**KIRKLEES METROPOLITAN COUNCIL  
INVESTMENT & REGENERATION SERVICE**

**DELEGATED DECISION TO DETERMINE PLANNING APPLICATIONS**

Reference No:	<b>2025/62/92216/W</b>
Site Address:	Butterley Leys Cottage, Spring Lane, New Mill, Holmfirth, HD9 7EH
Description:	Change of use of land to garden space, erection of single storey front extension and formation of 2 parking spaces
Recommending Officer:	Joanna Rednall

**DECISION – REFUSED**

Proposed front/west facing elevation (1:100).

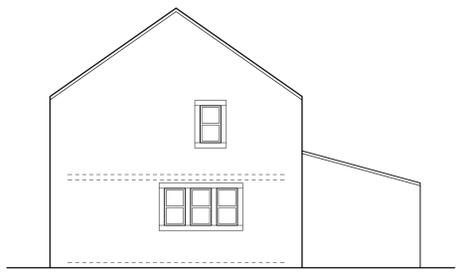
The proposed front extension, by virtue of its overall width, depth, and design, would span a substantial portion of the principal façade of the dwelling and would fail to appear subservient to the original built form. When viewed from the side elevations, the scale of the projection would appear particularly disproportionate relative to the depth of the original house forming an unsympathetic and obtrusive addition. The extension would significantly alter the visual massing of the dwelling from the western aspect, resulting in a development that would dominate the original structure.

Furthermore, the design of the windows proposed on the front (west-facing) elevation does not reflect the architectural style of the original house. The new windows, which differ in proportion and alignment, would contrast sharply with the existing vertically-oriented openings, creating a noticeable visual disconnect between the extension and the original building. This lack of consistency in window design and detailing would result in an unsympathetic addition that disrupts the balance of the façade and would undermine the character of the host dwelling.

Although the use of matching materials is acknowledged, this alone does not address the key concerns related to the extension's scale, proportion, and overall design. The choice of materials would not overcome the visual harm caused, as the extension would still appear overly prominent and out of keeping with the original building.

Block plan (1:500)

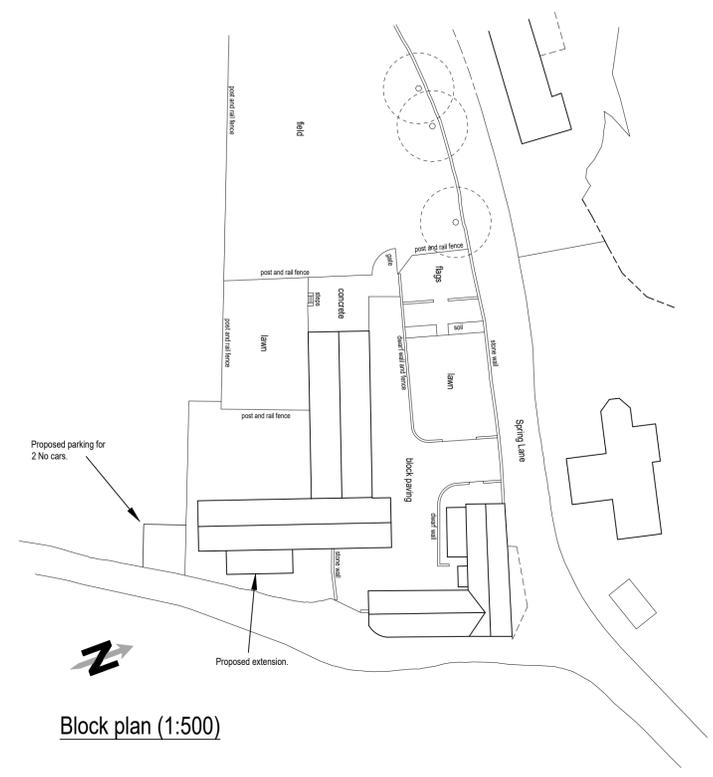
In addition to the proposed extension, the application also includes the change of use of a section of the existing soft landscaped garden area, located immediately to the south of the dwelling, to form a parking area for two vehicles. This area, measuring approximately 5.0 metres by 6.5 metres, is currently free from any built form and contributes positively to the open and undeveloped character of the surrounding land. The conversion of this green space into a domestic parking area would result in a significant visual change to the character of the land, resulting in urbanisation into an area that currently contributes to the openness of the Green Belt. This aspect of the proposal would result in an encroachment of the residential curtilage into an area of previously open land and would therefore conflict with one of the fundamental purposes of including land within the Green Belt, as set out in paragraph 143 of the NPPF. The introduction of a parking area in this location would represent an extension of residential curtilage into land that is not currently developed, thereby eroding both the spatial and visual openness of the Green Belt in this location.

As set out above in relation to the proposed parking area, the development would introduce a visually intrusive and urbanising feature onto land that is currently open and undeveloped. This would reduce the visual openness of the site, extend domestic use into the Green Belt, conflict with its intended purpose and rural character, and cause harm to visual amenity.
